From: Simon Davis
Sent: 14 April 2021 16:21
To: Luke Challenger [REDACTED]
Subject: Y/19/21/PL & Y/18/21/RES - Clays Farm North End Road Yapton BN18 0DT

Regarding Y/18/21/RES, I have now assessed the application and provide the following comments:

Project	Clays Farm, Yapton				
Drawing	House Type A22 (3 Block) Floor Plans				
Client	Aster Group				
Job no.	ASTE200629			Date	Jan'2021
Dwg no.	HT.A22(3Blk).p			Rev.	A
Author	MS	Checker	AS	Scale	1:100 at A3
Status	PLANNING			Office	Romsey
Client ref.

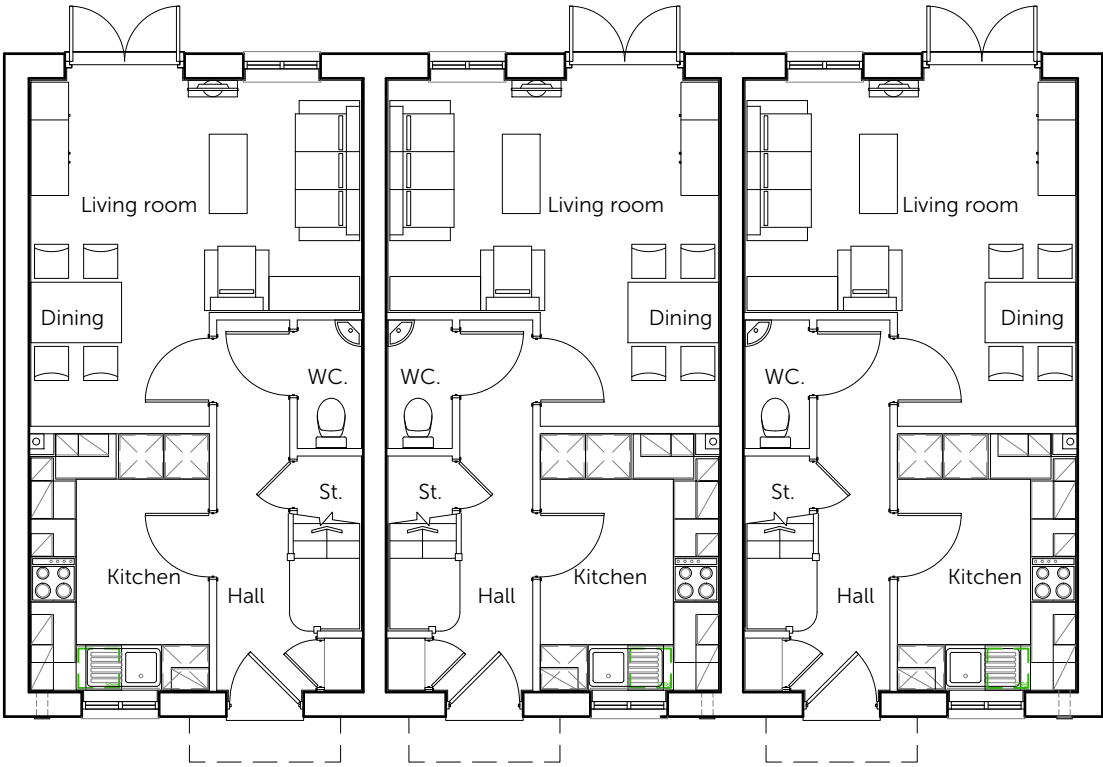
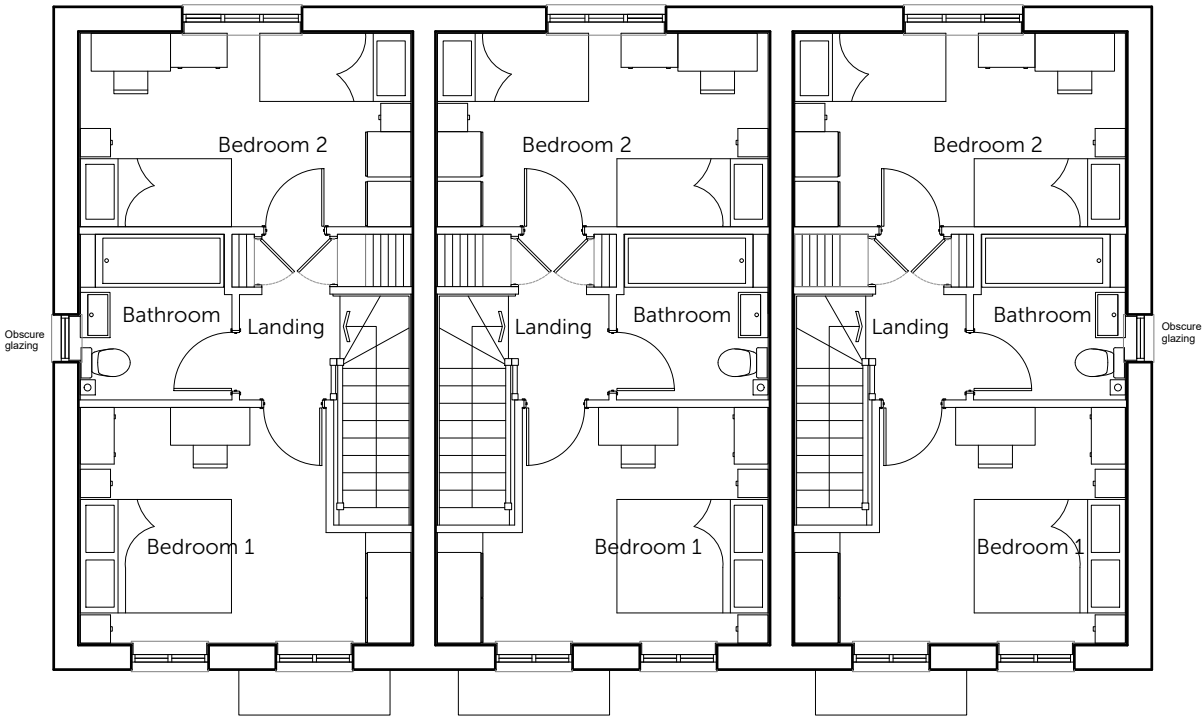
- It appears that the garages are undersized versus the standard in the Arun Design Guide. To be counted as half a space each, garages must be at least 6m by 3m. The garages in the scheme are 5.88m by 3.09m. However, even if the garages are not included, the parking provision still exceeds the requirement so there is no need to enlarge these.

- I have a concern with the 2 visitor spaces in front of plots 31-33. I believe that in this position they will just be used by the occupiers of those homes. I suggest relocating these to the opposite side of the road and further west into the site.
